Re : Planning Application P/53/19/L for Listed Building Consent for the Inglenook Hotel. Deadline for objections 1st August.

I would like to object, on behalf the residents of the Mill Farm Estate, to the above Listed Building Consent for the demolition of a chair store and realignment of curtilage listed wall. The reason given for the demolition and realignment is to enable a safe access to a proposed development to the rear of the Inglenook.

Jane Collins
Chair
Mill Farm Resident Association

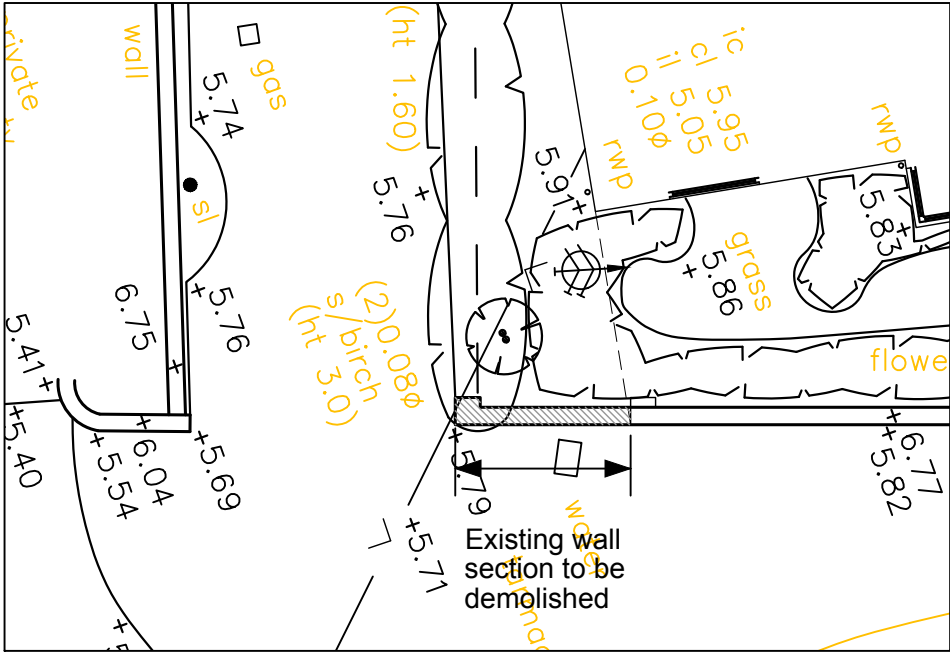
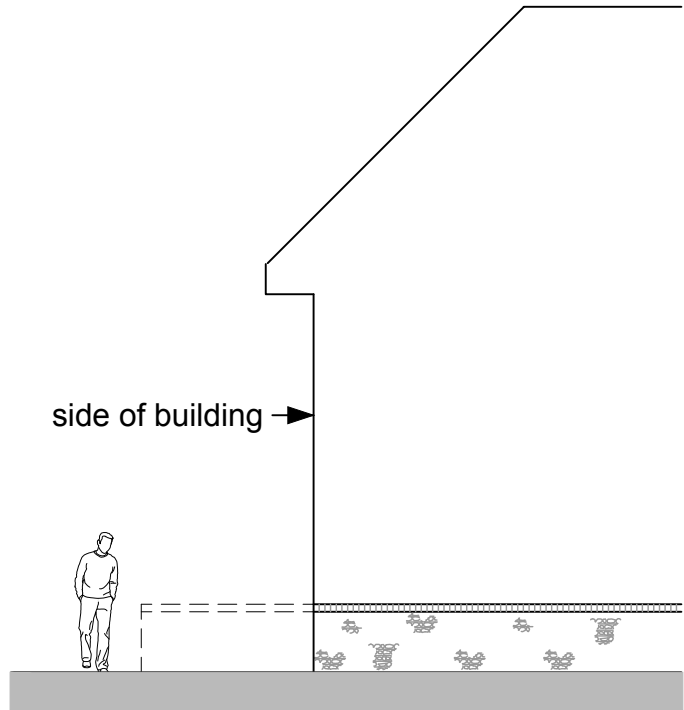
The Listed Consent statement considers demolition and realignment will not be harmful to the heritage asset. There is no evidence of assessment or of expert consultation

The limited widening of the access road will significantly increase vehicle movements entering and exiting the site onto the Pagham Road and will have an adverse effect on highway safety and convenience of road users. (The Block Plan 31 does not show the benefit of realignment of the wall or removal of the store with regard to the overall width of access being achieved). This information has been supplied in the proposed planning application which states it will be increased from 3.5m to 5.3m after alignment. An example of vehicle widths: A BMW X5 is 2.4m wide, average car 2m, refuse/commercial vehicle 3m wide. In addition it is proposed that pedestrians will be using a shared surface in the access lane.
